Great North Road Solar and Biodiversity Park

Final Statement of Common Ground with Nottinghamshire Wildlife Trust

Document Reference – EN010162/APP/8.11C

April 2026

Great North Road Solar and Biodiversity Park Environmental Statement

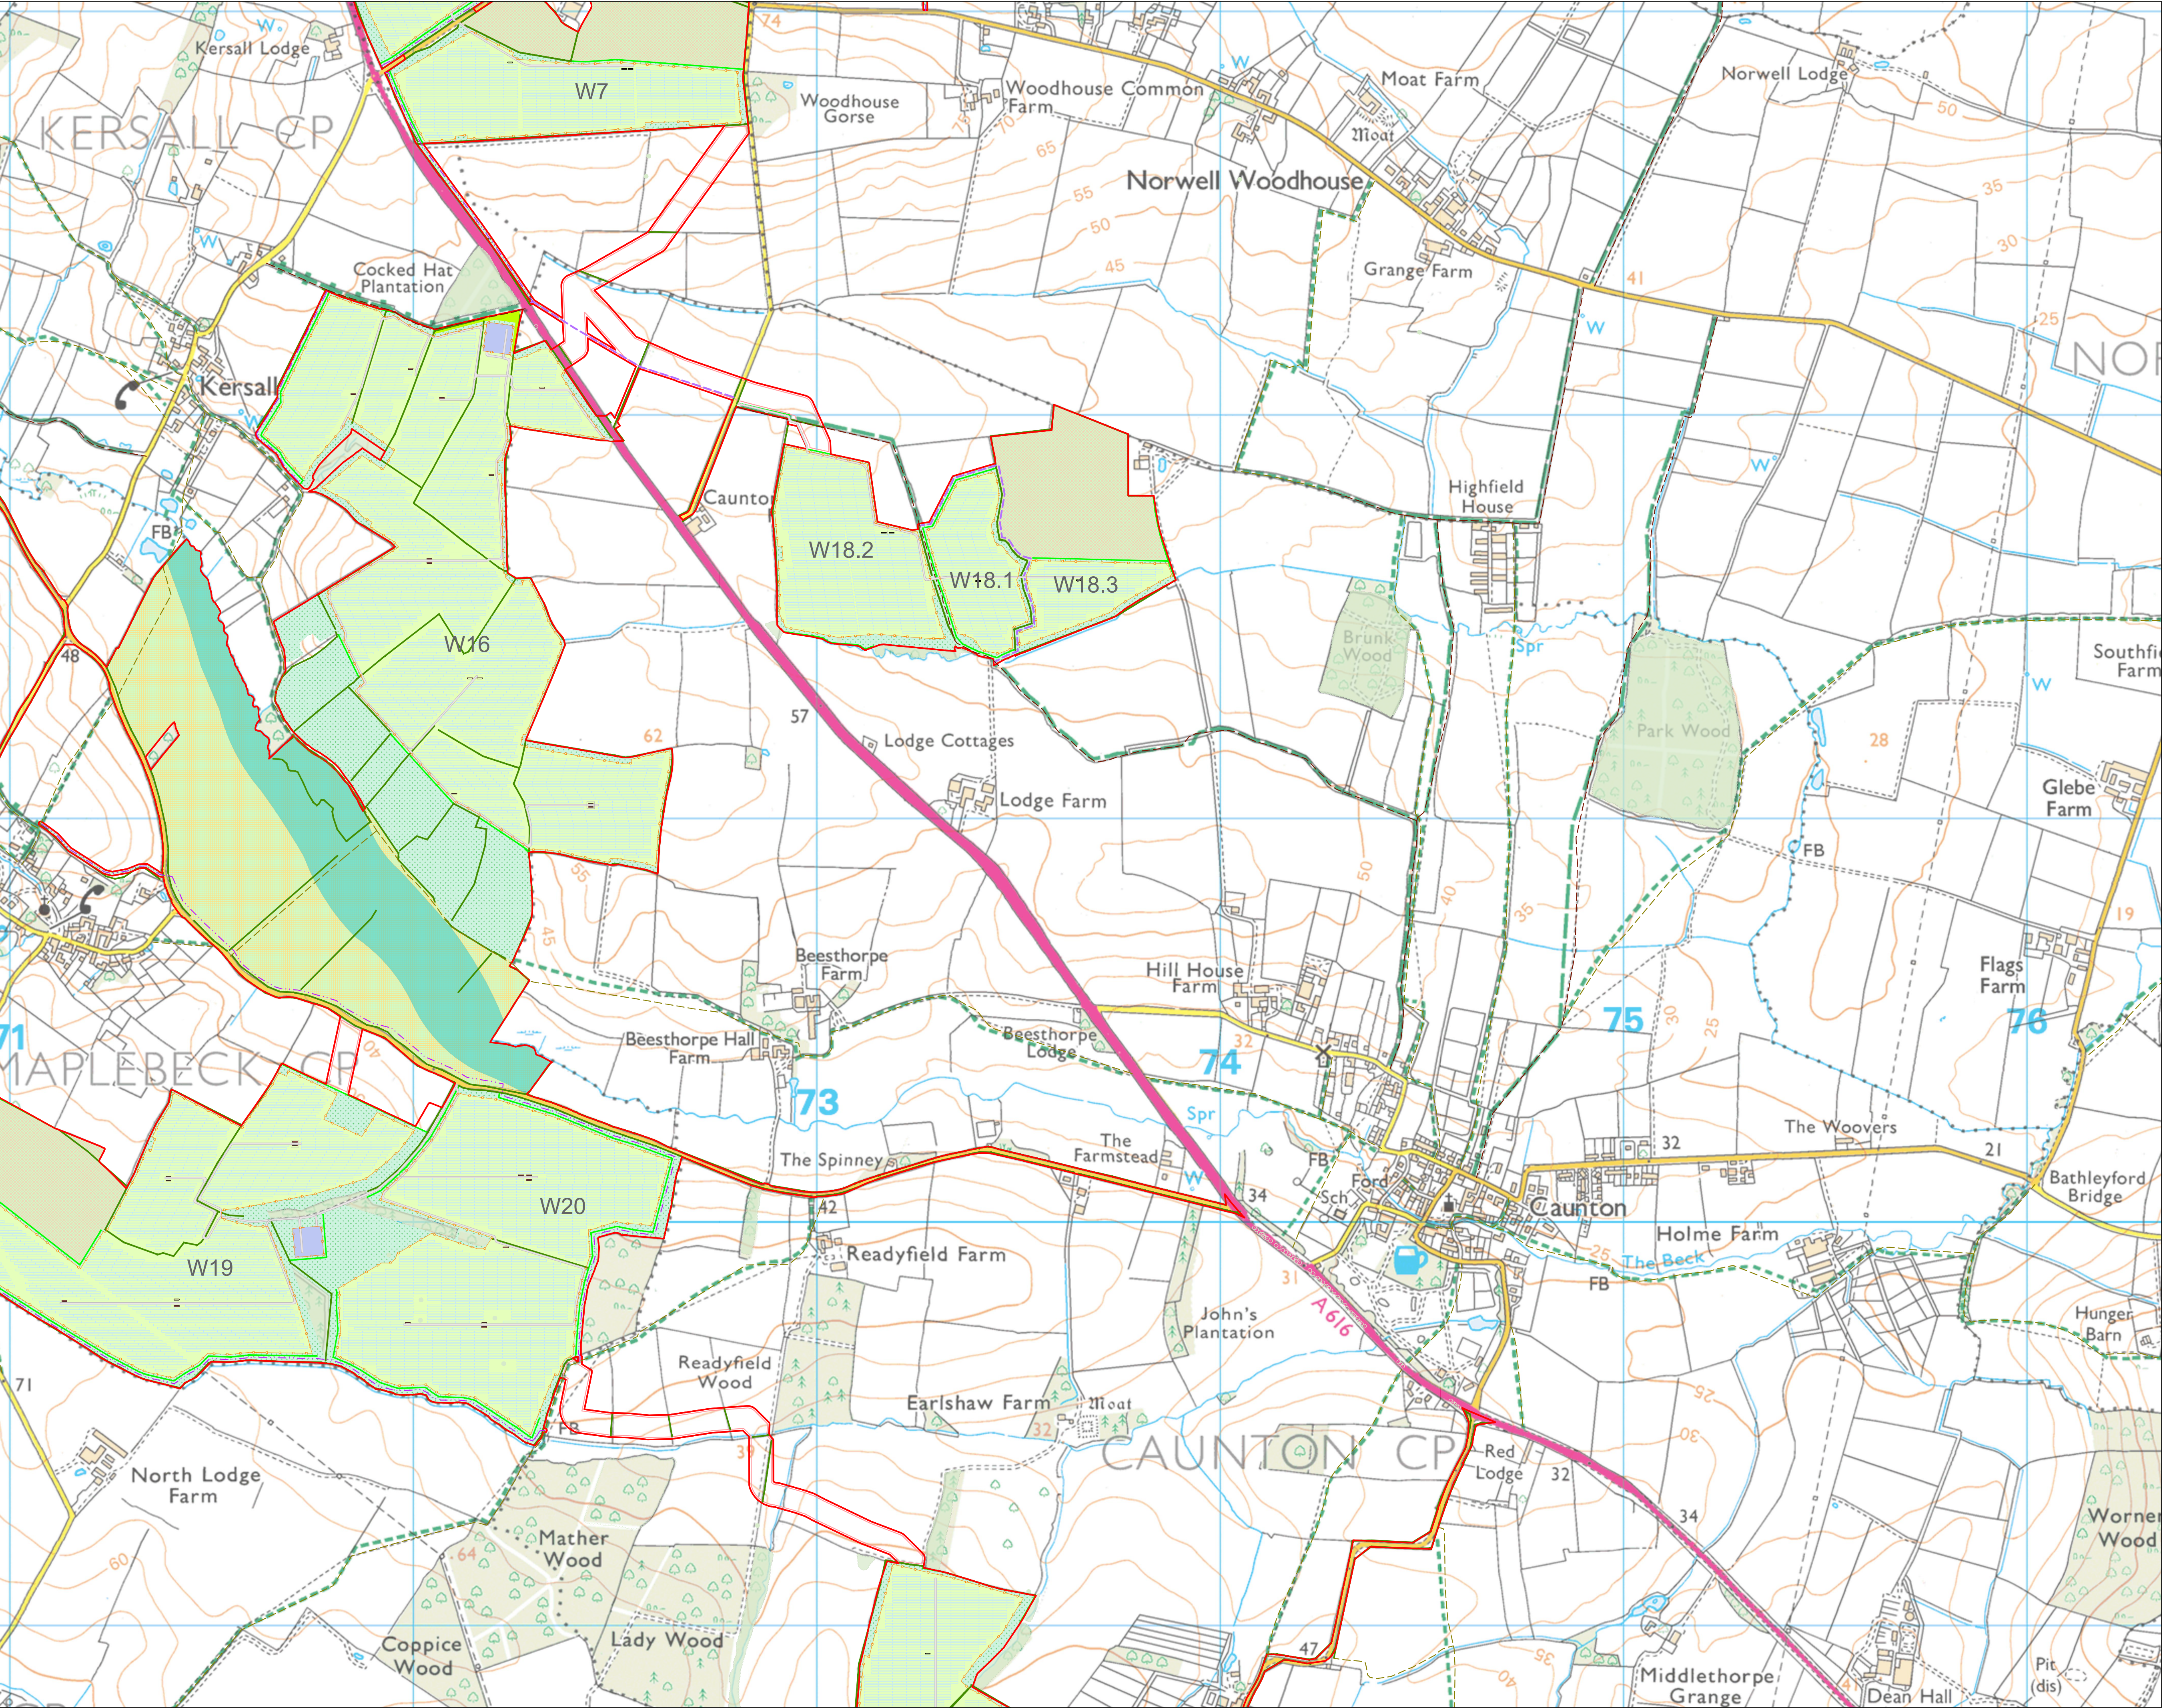
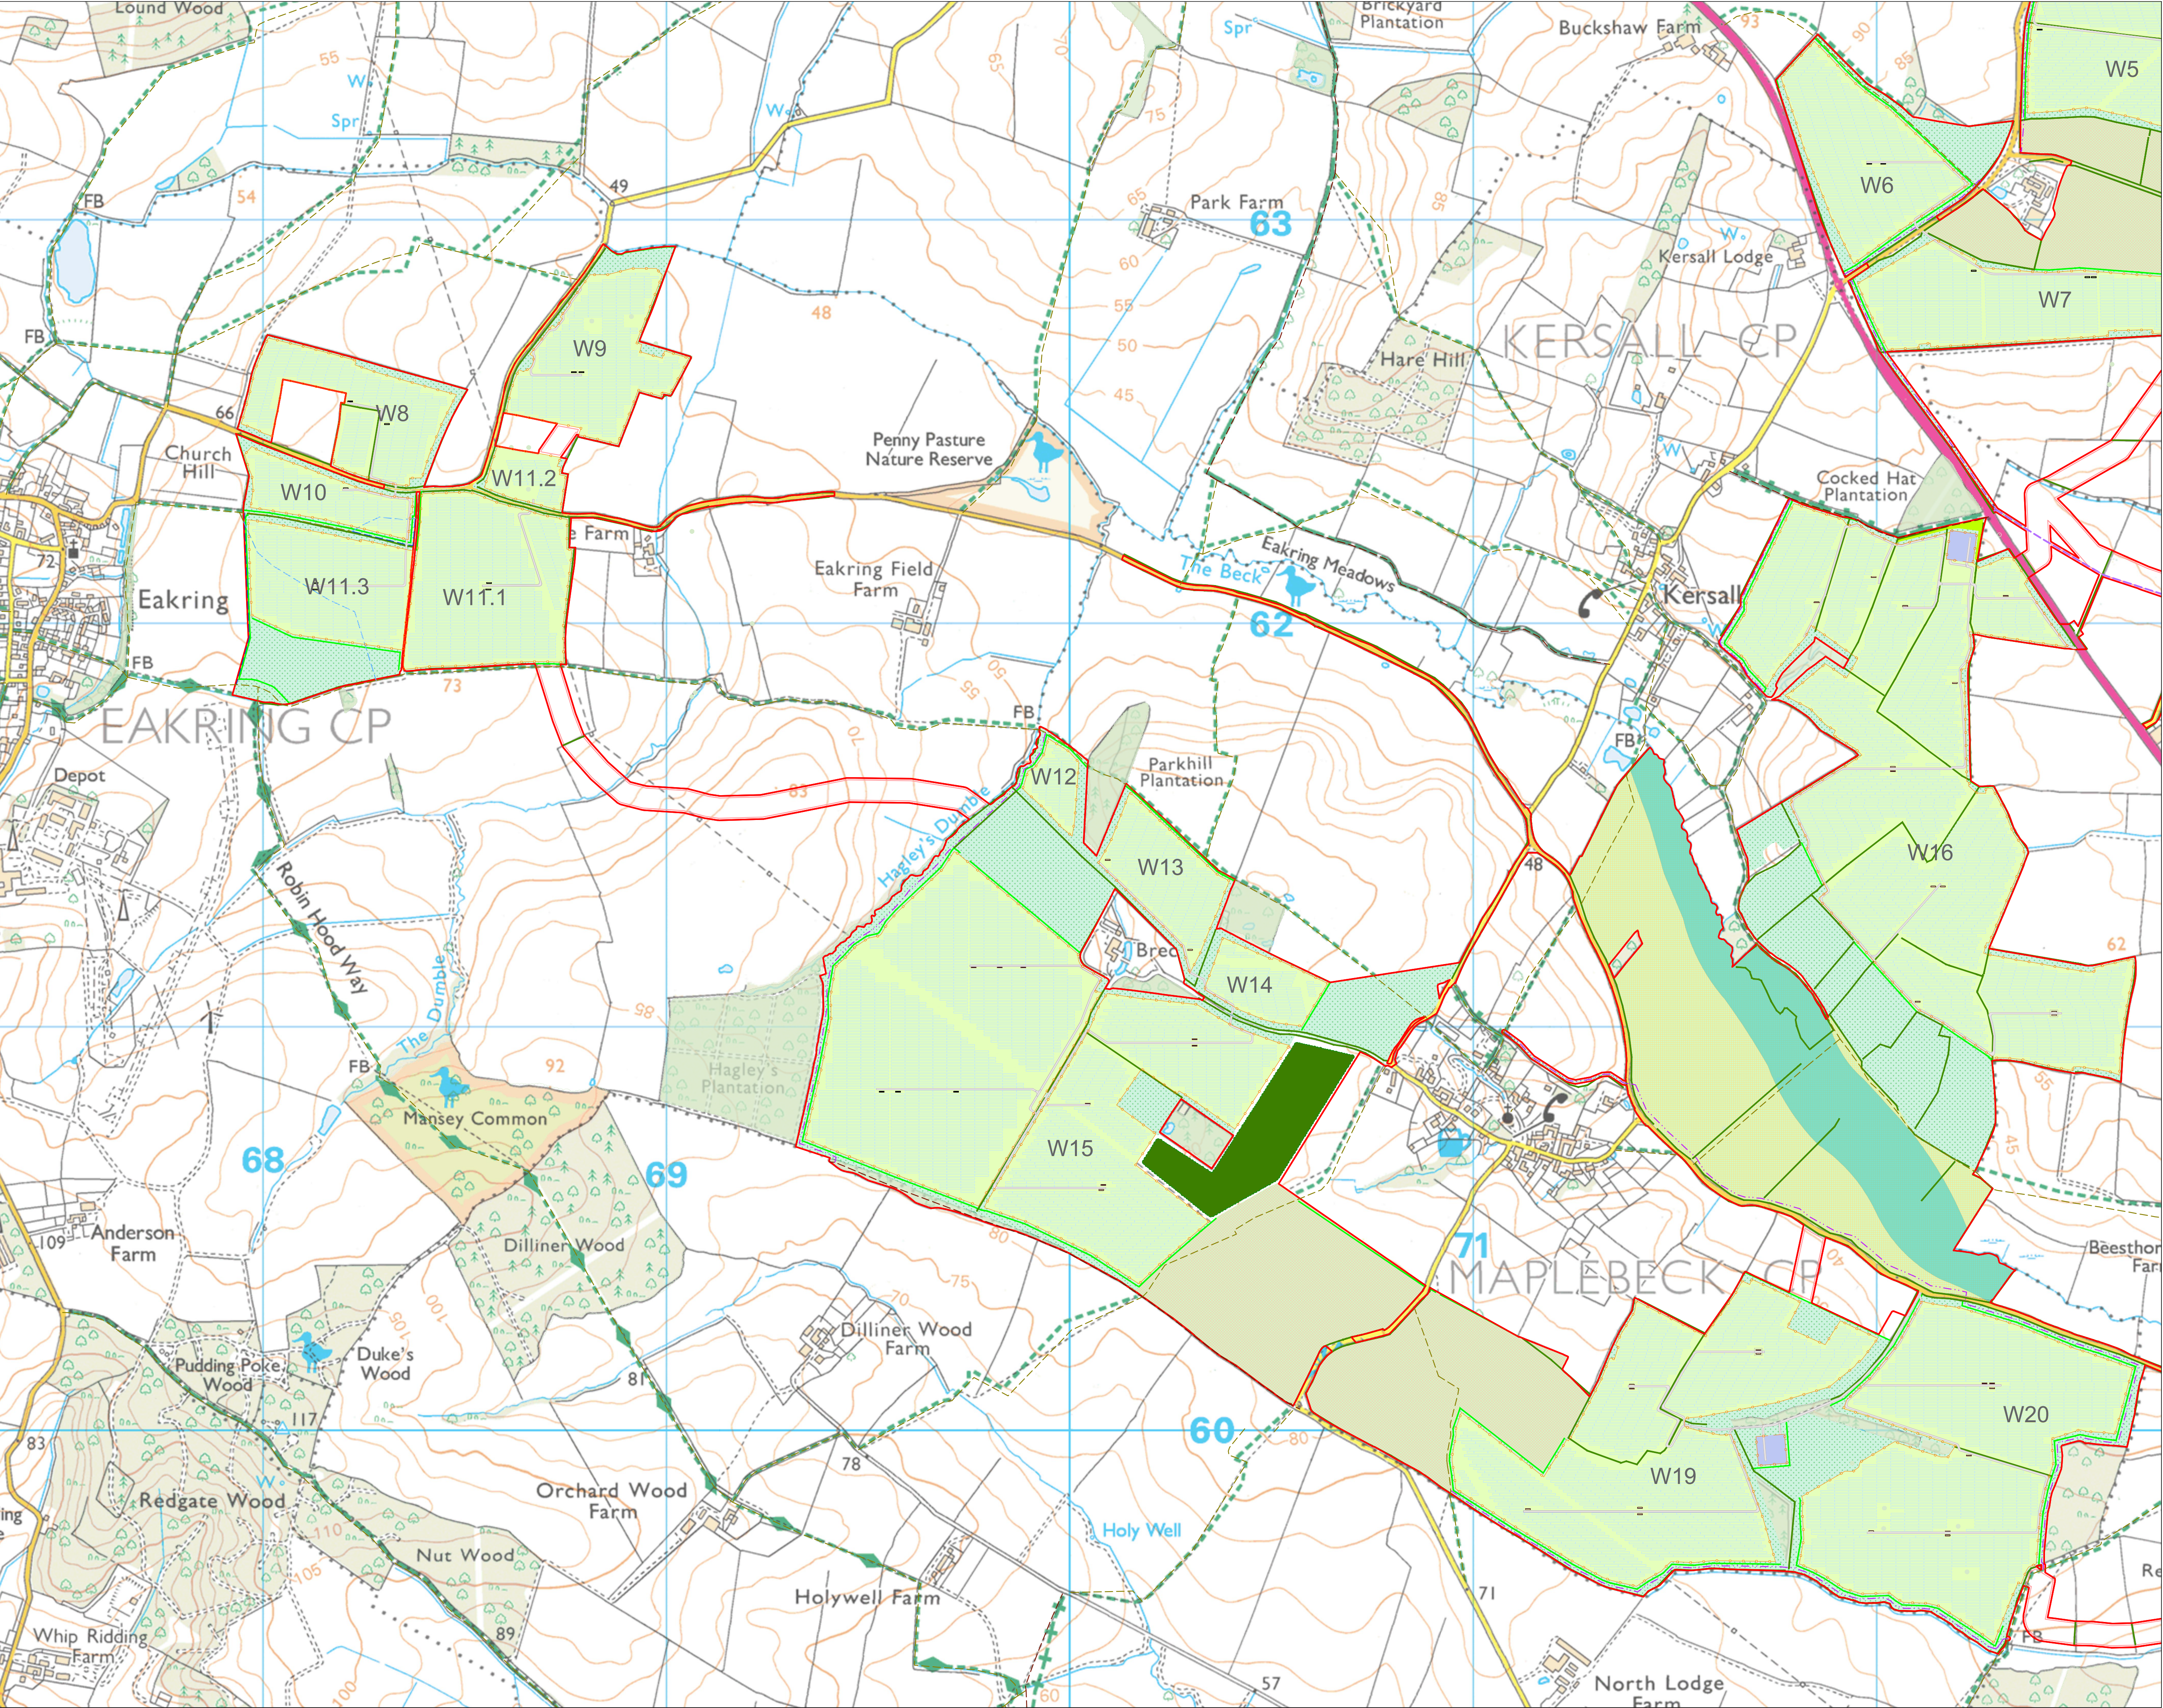
2.2.9	Meeting (27/01/2026)	Scattered tree planting	Concerned that tree planting in or near open areas would discourage nesting birds such as lapwing and waders. Recommend that black poplar is included in the tree planting specification.	The specification of the tree planting in the riparian corridor has been revised in section 22 of Table A5.1.5 in ES Volume 4, Appendix A5.1: Outline LEMP [EN010162/APP/6.4.5.1C] [REP3-032] to make clear that the locations of tree planting will be selected to limit their potential to discourage nesting birds. The locations shown on the Masterplan are therefore purely indicative. Black poplar has been added to the specification.	Agreed
